Current Zoning: UC (urban core)
 Proposed Zoning: UMUD-O (uptown mixed-use district, optional)

Approximately 2.766 acres located on the west side of S Tryon Street, north side of Carson Boulevard, and east side of Winnifred Street.

The petition proposes development of the site under the provision of the UMUD zoning district with additional optional provisions.

SHEET NUMBER
RZ-1.00

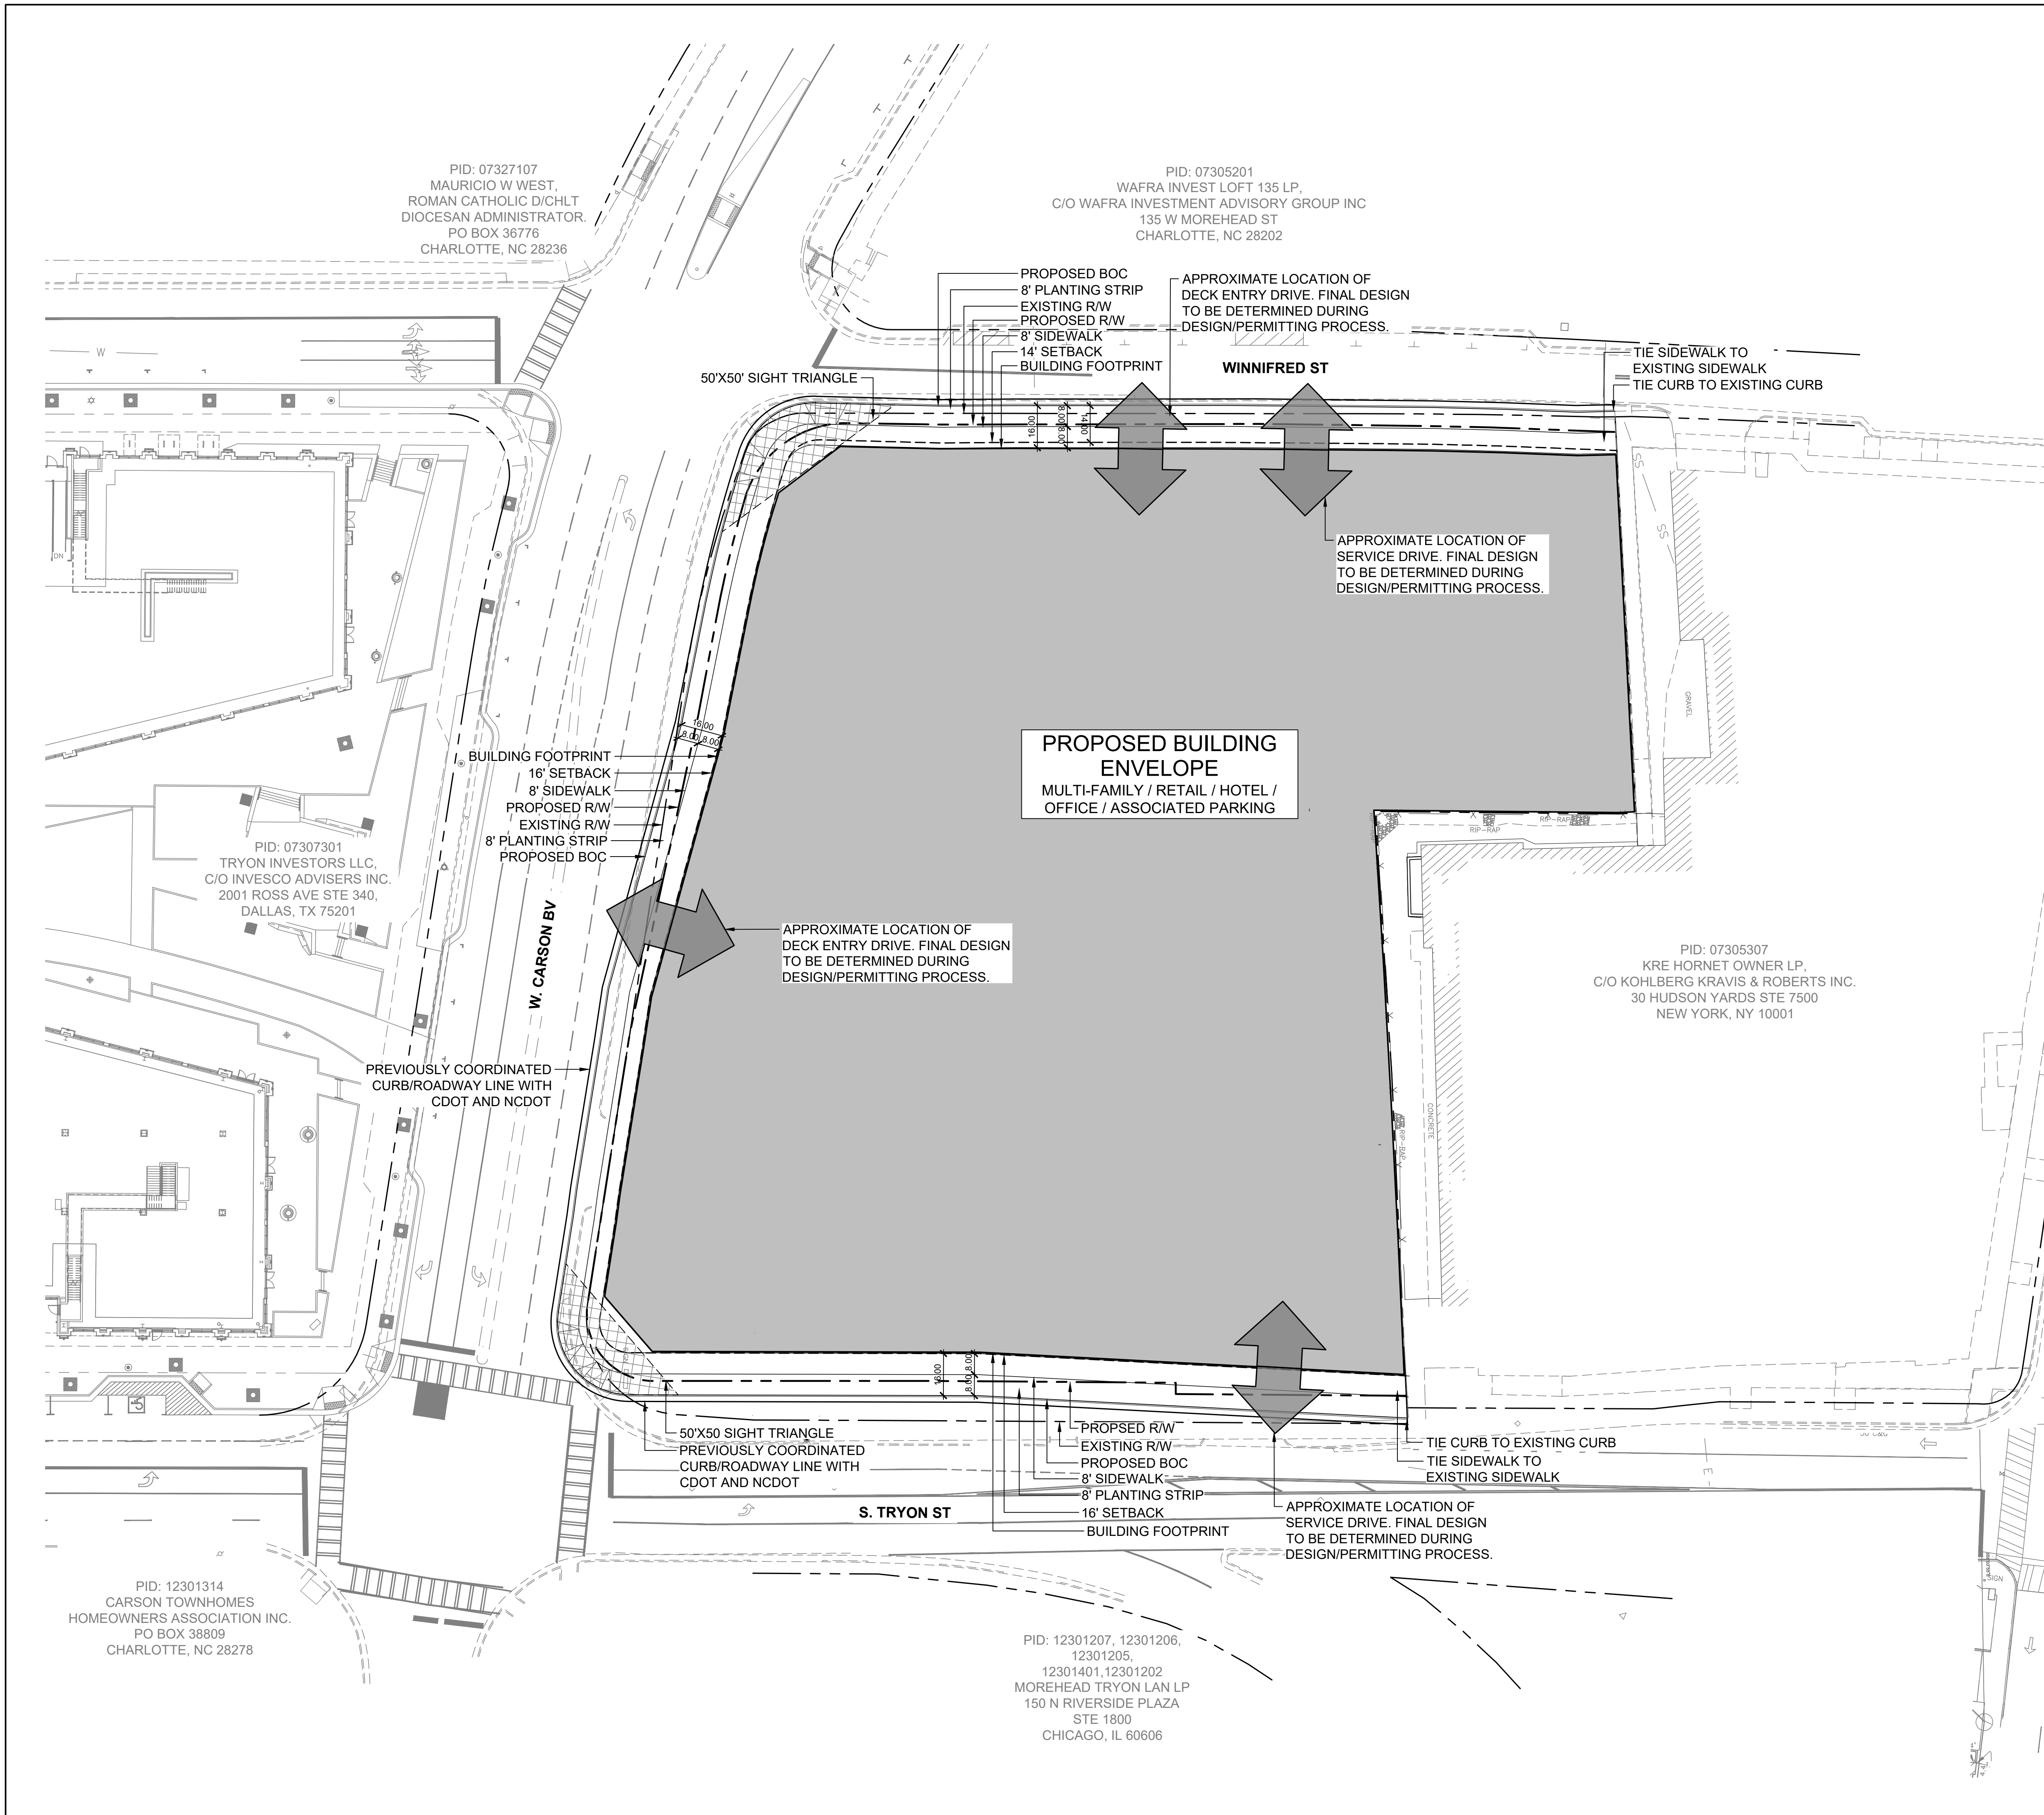
1. Curb lines need to be dimensioned on the site plan for each public road. Previously coordinated back of curb locations will be used.
2. CATS requests the construction of ADA compliant bus standard detail 60.01A on South Tryon Street. The final location will be coordinated with the developer during the Land Development plan review process.
